Application for a non-material amendment following a grant of planning permission.
 Town and Country Planning Act 1990

ERECTION OF A SINGLE STOREY EXTENSION TO REAR ELEVATION TO CREATE LIVING SPACE, WHICH WILL ALLOW A DOWNSTAIRS BEDROOM AND SHOWER ROOM TO BE INSTALLED AT THE FRONT OF THE PROPERTY FOR A DISABLED PERSON

21 / 03571 / FUL

DWG. STATUS	For Planning			
SCALE	1:125	@ A3		
DRAWN BY	A Bain			
DATE	July 2020			
UPDATED	-	REV.	05	
AREA	PROP.	PHASE	AEMFS	SHEET
177	DFG	01	A	01

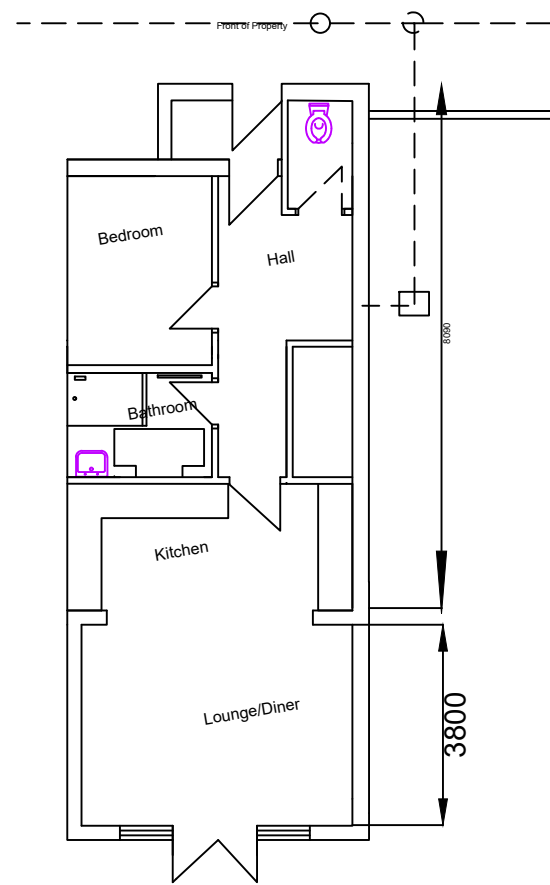
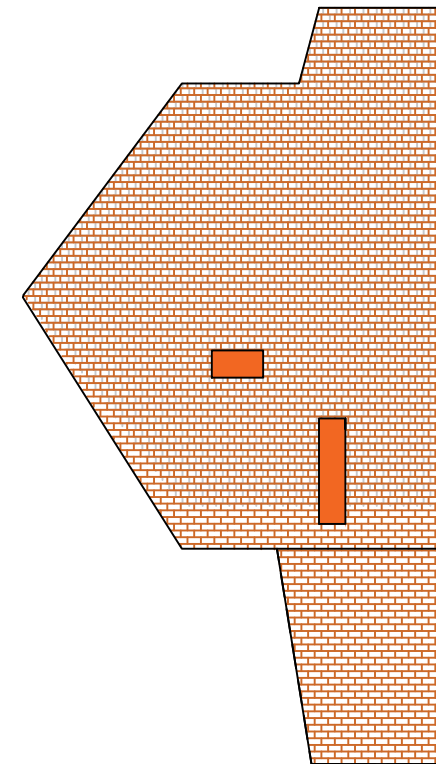
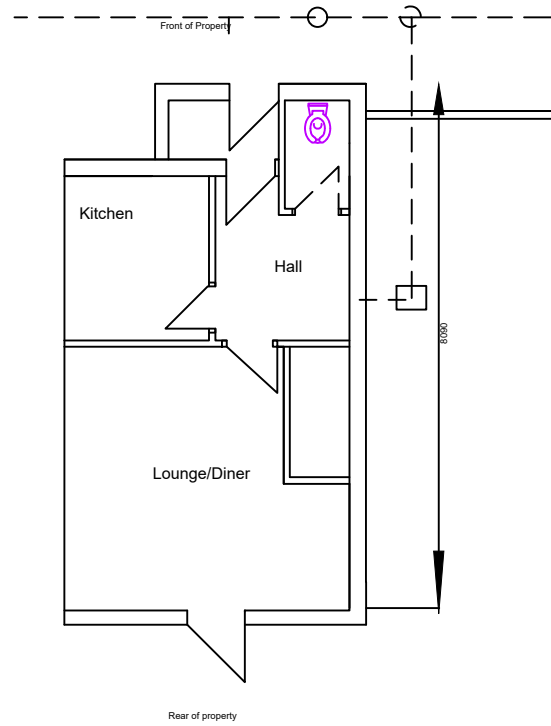
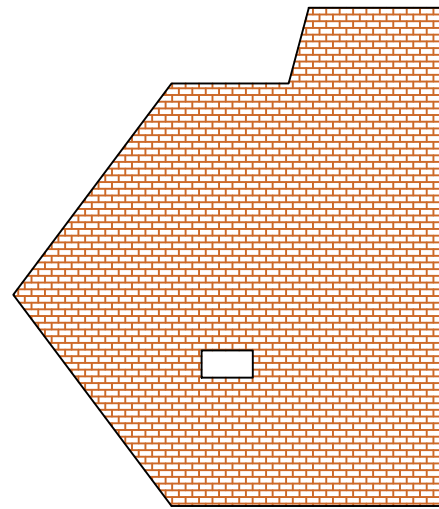
(A) TO INCREASE THE INTERNAL DEPTH OF THE EXTENSION TO 3.80m FROM 3.30m

(B) TO WIDEN THE GLAZING AT THE REAR TO PROVIDE MORE LIGHT INTO THE ROOM
